**Application by Associated British Ports for the Immingham Green Energy Terminal  
The Examining Authority's written questions and requests for information (WQ2)  
Issued on Friday 17 May 2024**

**Responses are due by Deadline 4: Tuesday 4 June 2024.**

Appendix 1: Environmental Statement, Chapter 13, Figure 13-6 (Designations)

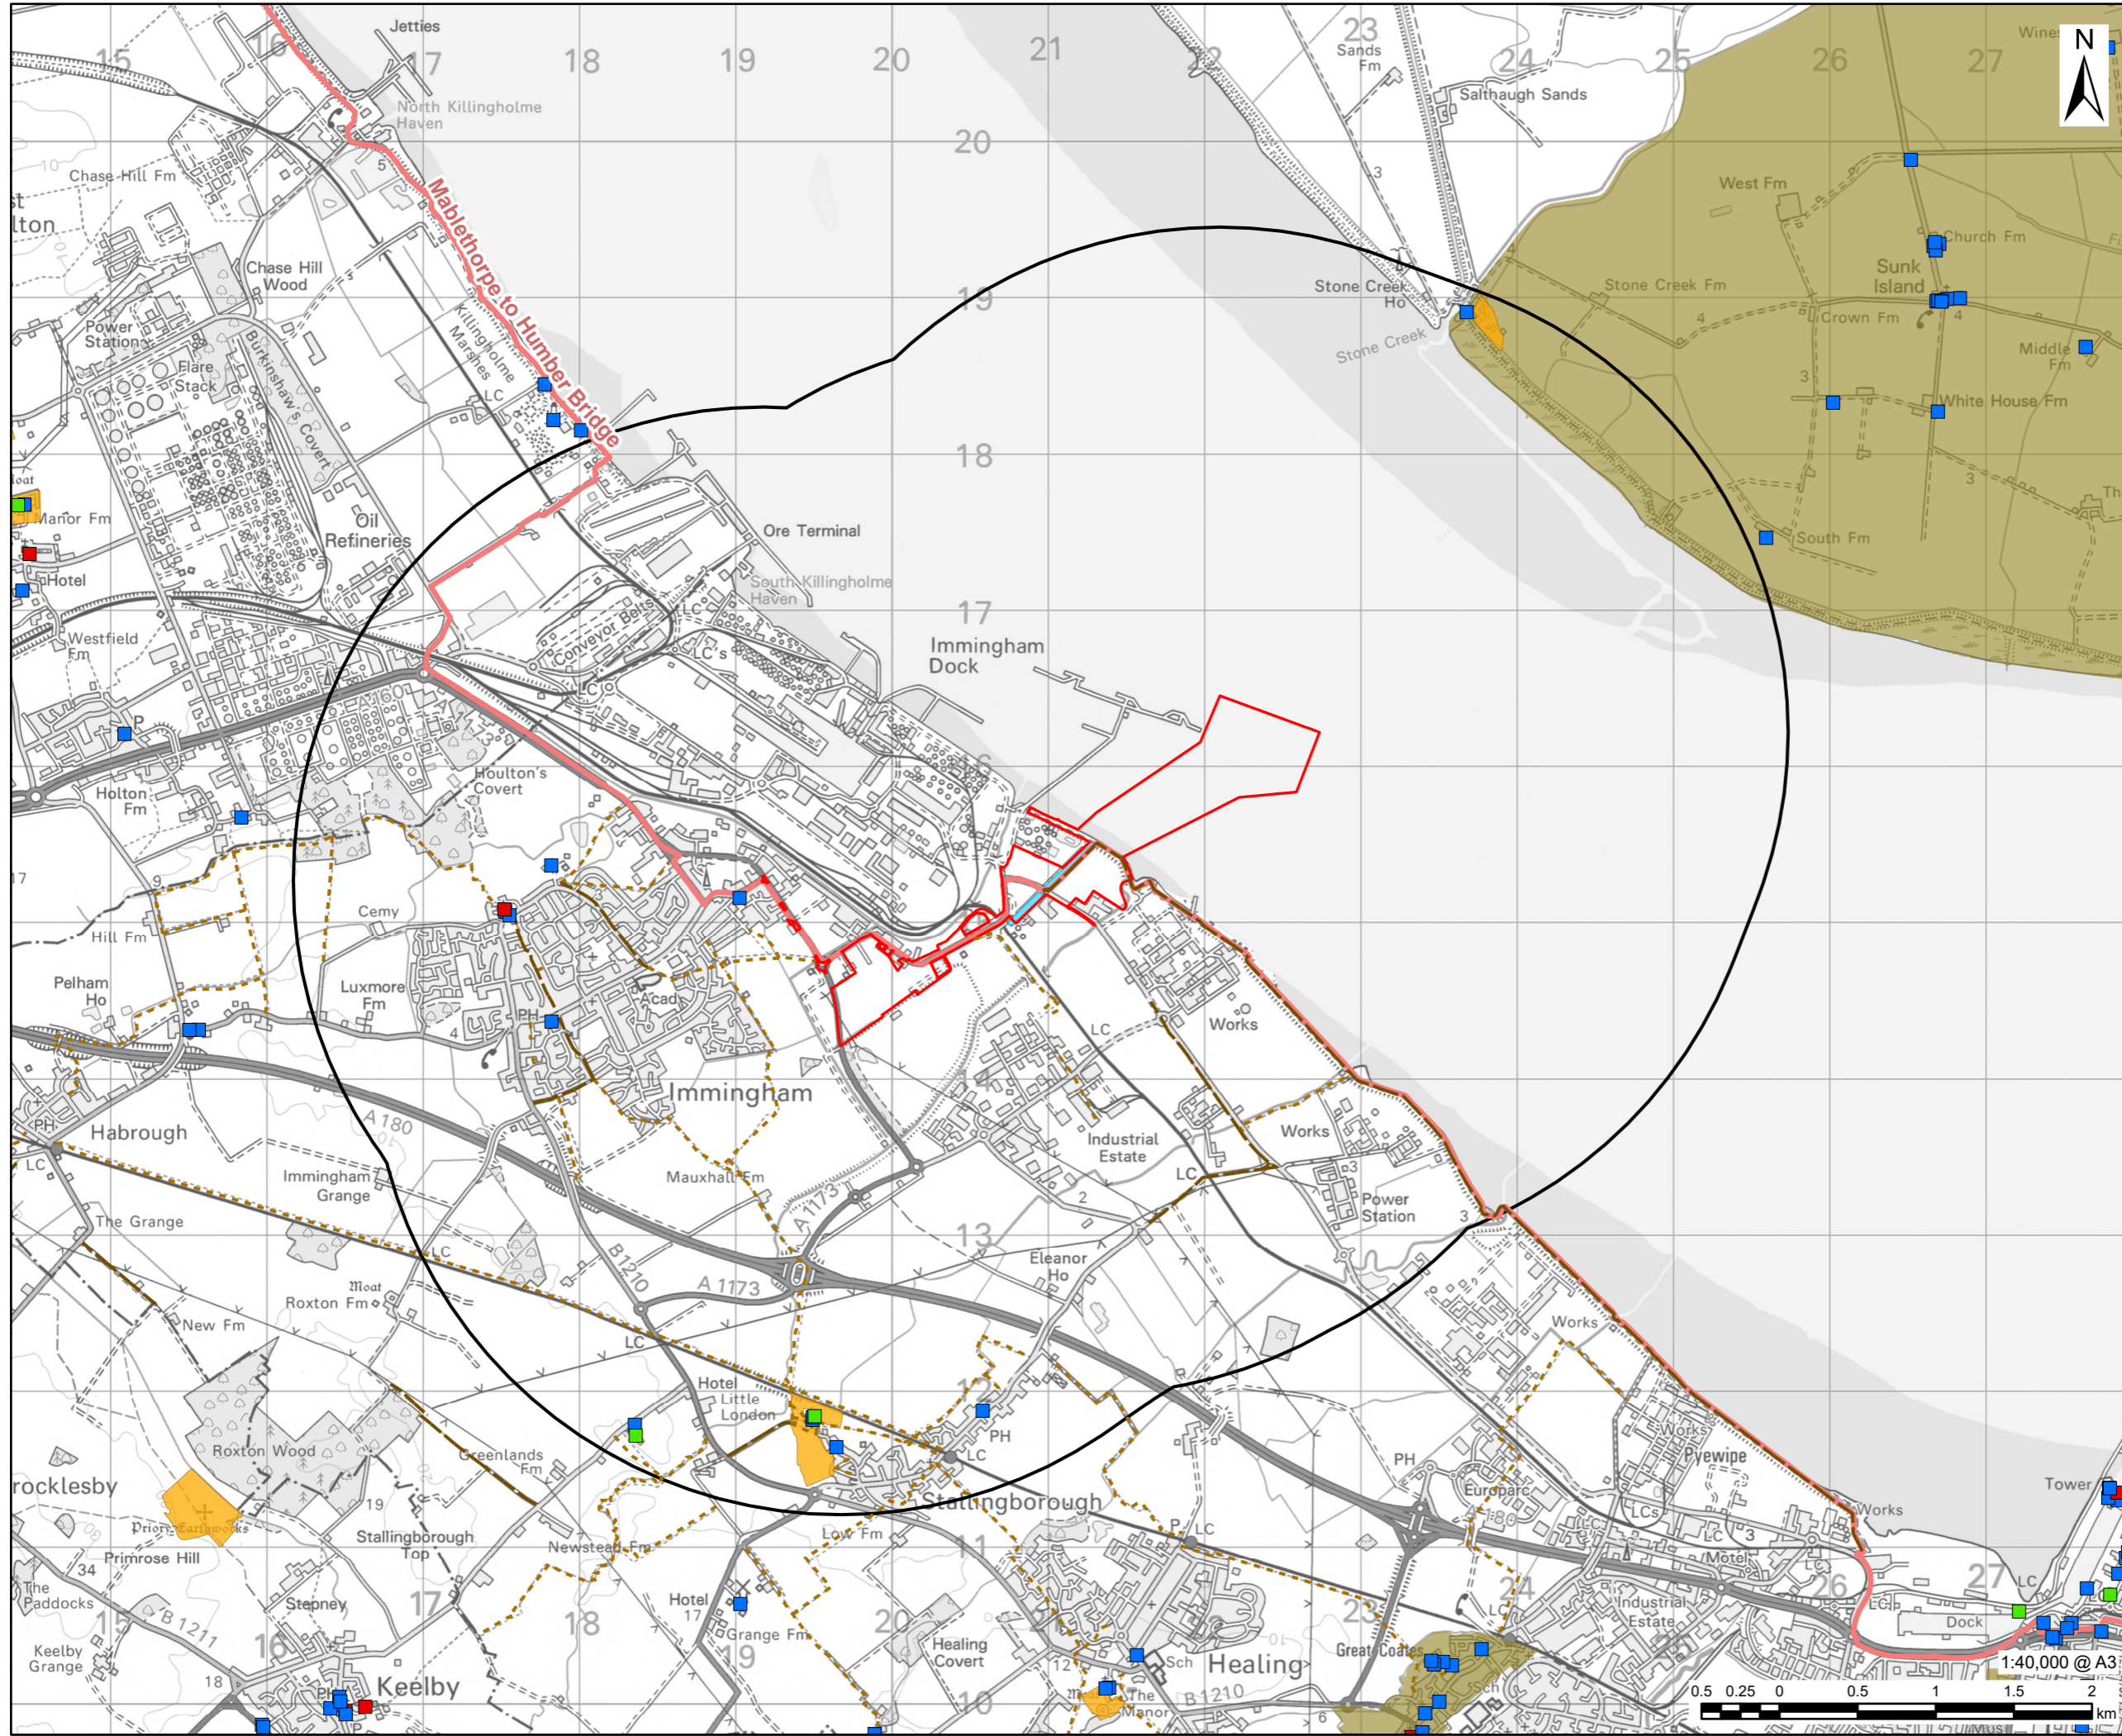
GEN 2.3	The Applicant	<p><b>Proposed England Coast Path</b></p> <p>Figure 13.6 (Designations) [REP3-093] shows part of the Proposed England Coast Path running through the Order Limits. What provision has been made within the application to accommodate this?</p> <p>Should this be a drafting error and the Path is not proposed to cross the application site, provide a corrected plan, along with a written description of the route of the proposed Path in relation to the Order Limits.</p>
<b>2. Principle of Development</b>		
POD 2.1	The Applicant	<p><b>Tilbury 2</b></p> <p>The Applicant references Tilbury 2 and the division of the NSIP and the Associated Development in that case. For clarity, does the ExA Recommendation Report or the SoS Decision for Tilbury 2 analyse the relevance of the wording <i>'capable of handling the</i></p>

Appendix 6: Updated Long Sections for West Site

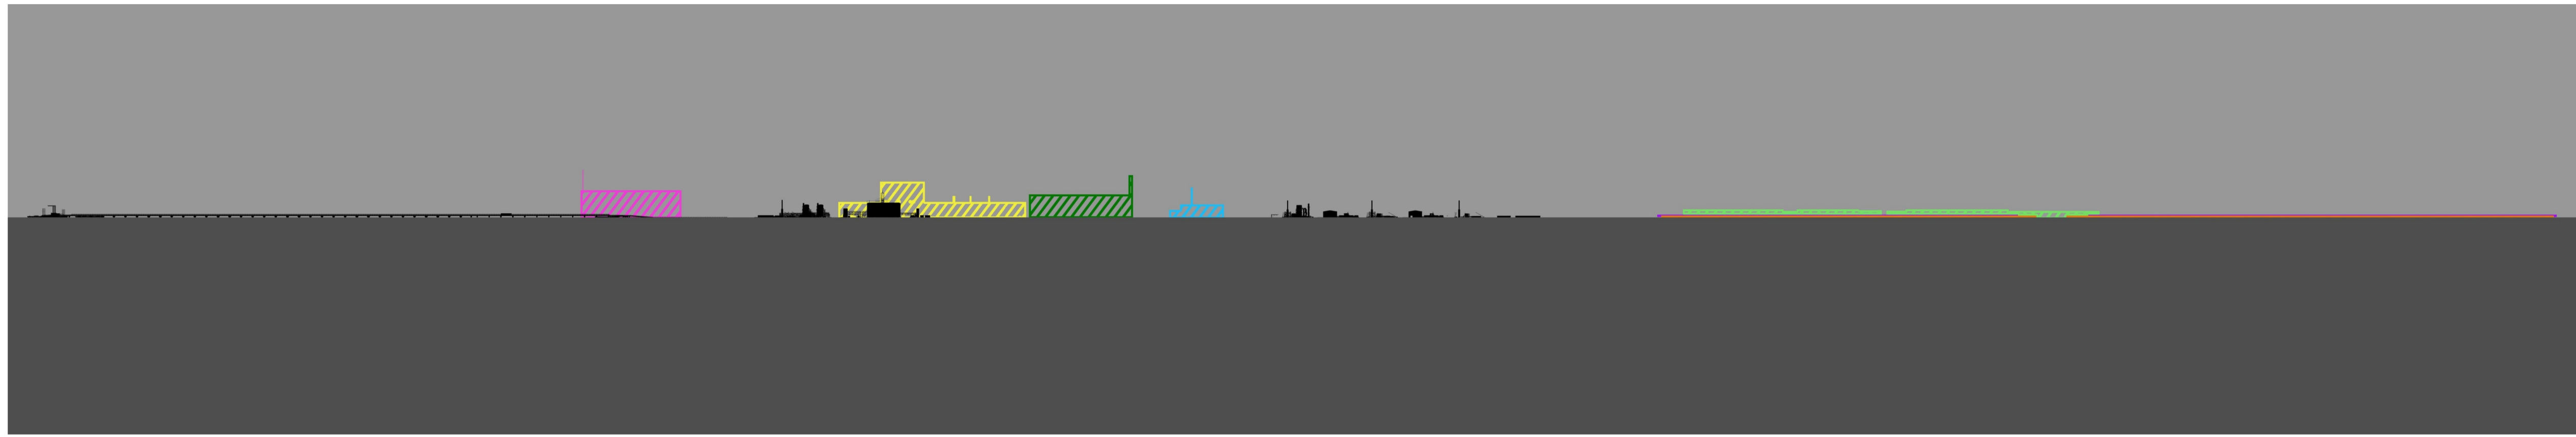
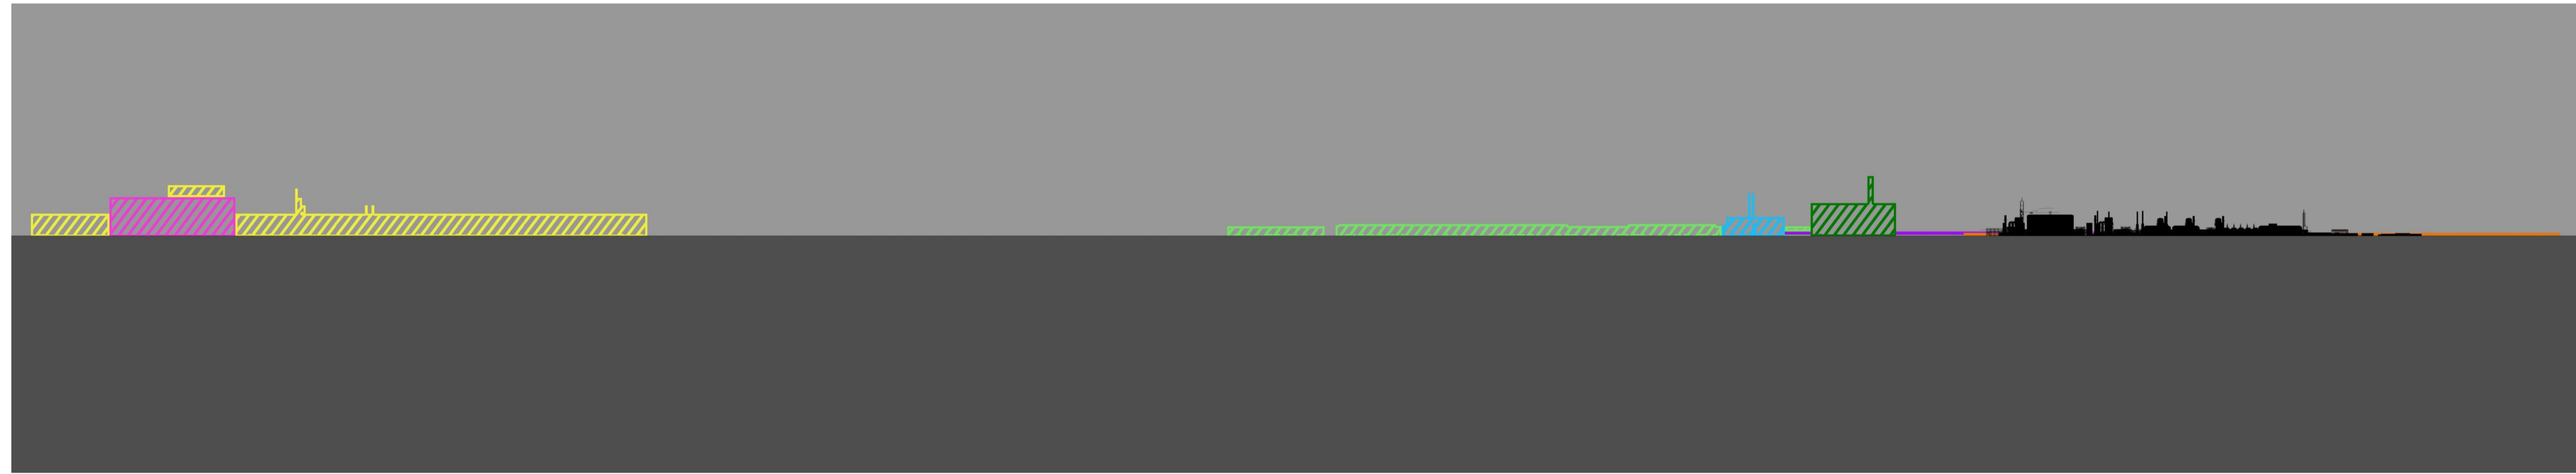
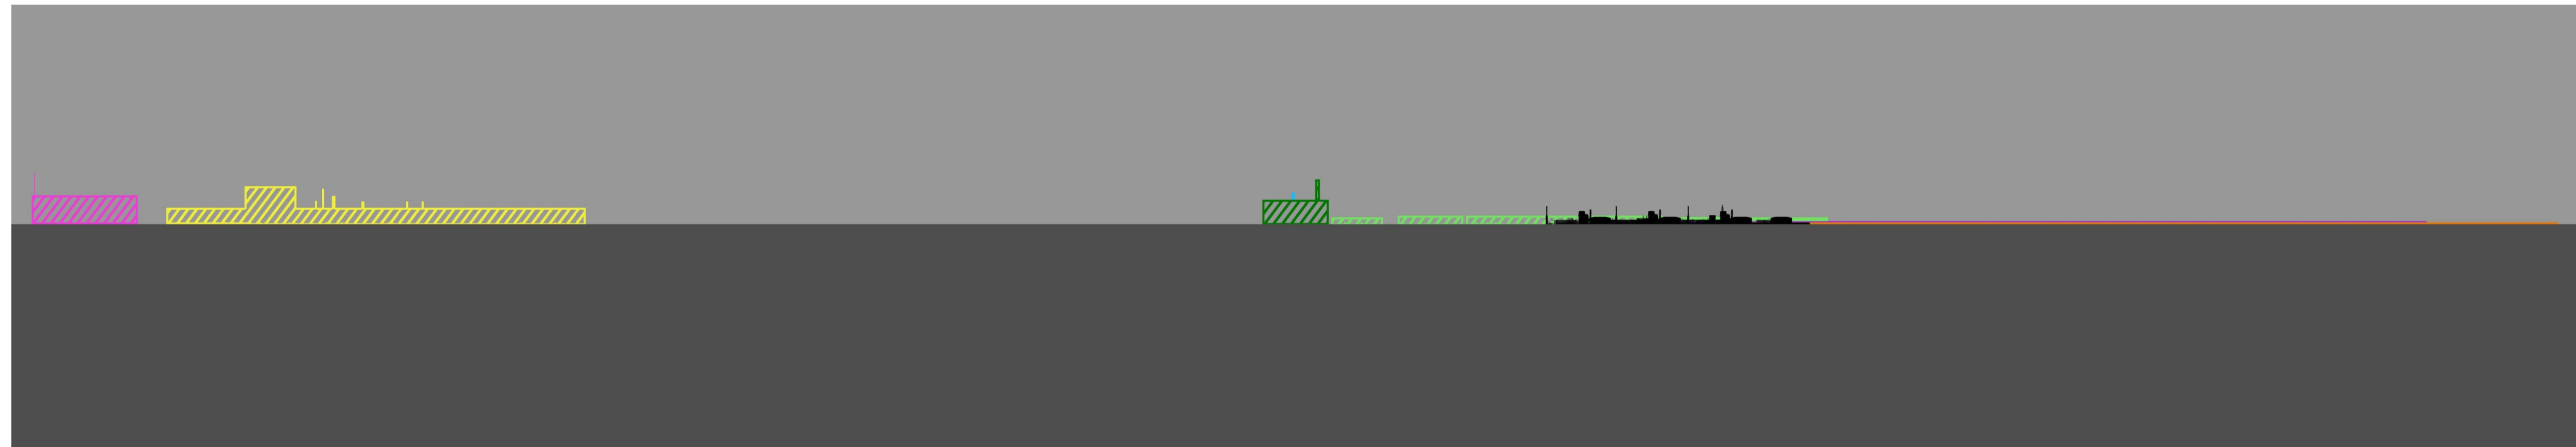
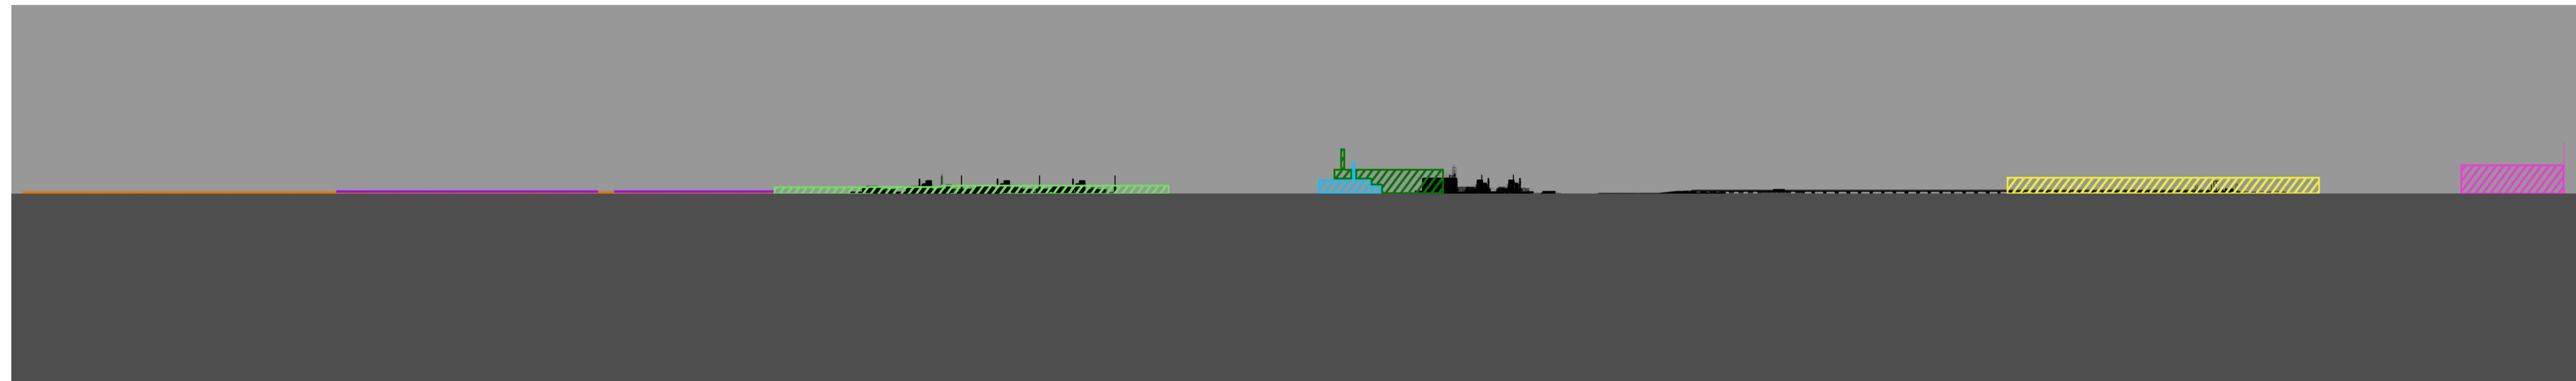
<b>7.</b>	<b>Landscape and Visual Effects</b>	
LV 2.1	The Applicant	<p><b>Scale of Buildings on the West Site</b></p> <p>The Applicants Response to ISH5 Action Points [REP3-065, Appendix 2, Appendix 3] provides useful long sections that indicate the scale and massing of the Proposed Development (West Site) in the context of other existing or consented developments.</p> <ul style="list-style-type: none"> <li>• Indicate on the key map the direction of view for each section.</li> <li>• An additional section is required. Looking north east, on a north west – south east axis along a line or relevant length drawn from where Manby Road enters the Key Map (top left hand edge) to where the A180 leaves the Key Map (right of centre, bottom edge).</li> </ul>
LV 2.2	The Applicant North East Lincolnshire Council	<p><b>Queens Road Properties</b></p> <p>The Applicant has provided a response to Questions and Action Points regarding the future of the Queens Road properties [REP3-065]. It is submitted that the buildings in terraces 1 – 6 and 7 - 18 will be demolished and the area shall be left with a general hardcore surface awaiting future development, either by Air Products or a third party.</p> <p>In accordance with paragraph 5.1.16 of the NPSfP, and in order to achieve the objectives of Good Design, the ExA would expect to see some softening of this area, rather than simply a</p>

Appendix 7: Queens Road Map

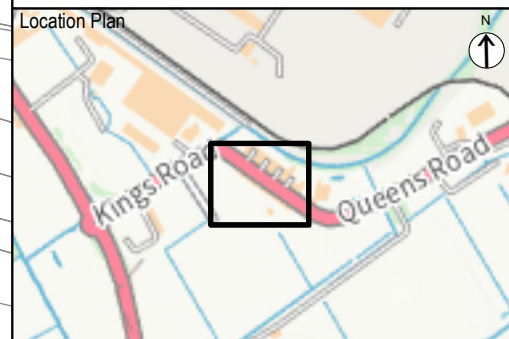
16.	<b>Cumulative Effects and In-combination effects</b>	
		<b>No specific questions at this time</b>
17.	<b>Compulsory Acquisition and Temporary Possession</b>	
CATP 2.1	The Applicant	<p><b>Queens Road map</b></p> <p>At CAH1 the ExA asked the Applicant to submit an inset map, at a larger scale, of the Queens Road properties (Action Point 3). At D3 two inset maps were submitted covering the area. The Applicant is requested to combine these to create one map, showing all the Queen's Road properties (Nos. 1 to 31) and immediate surrounds.</p>
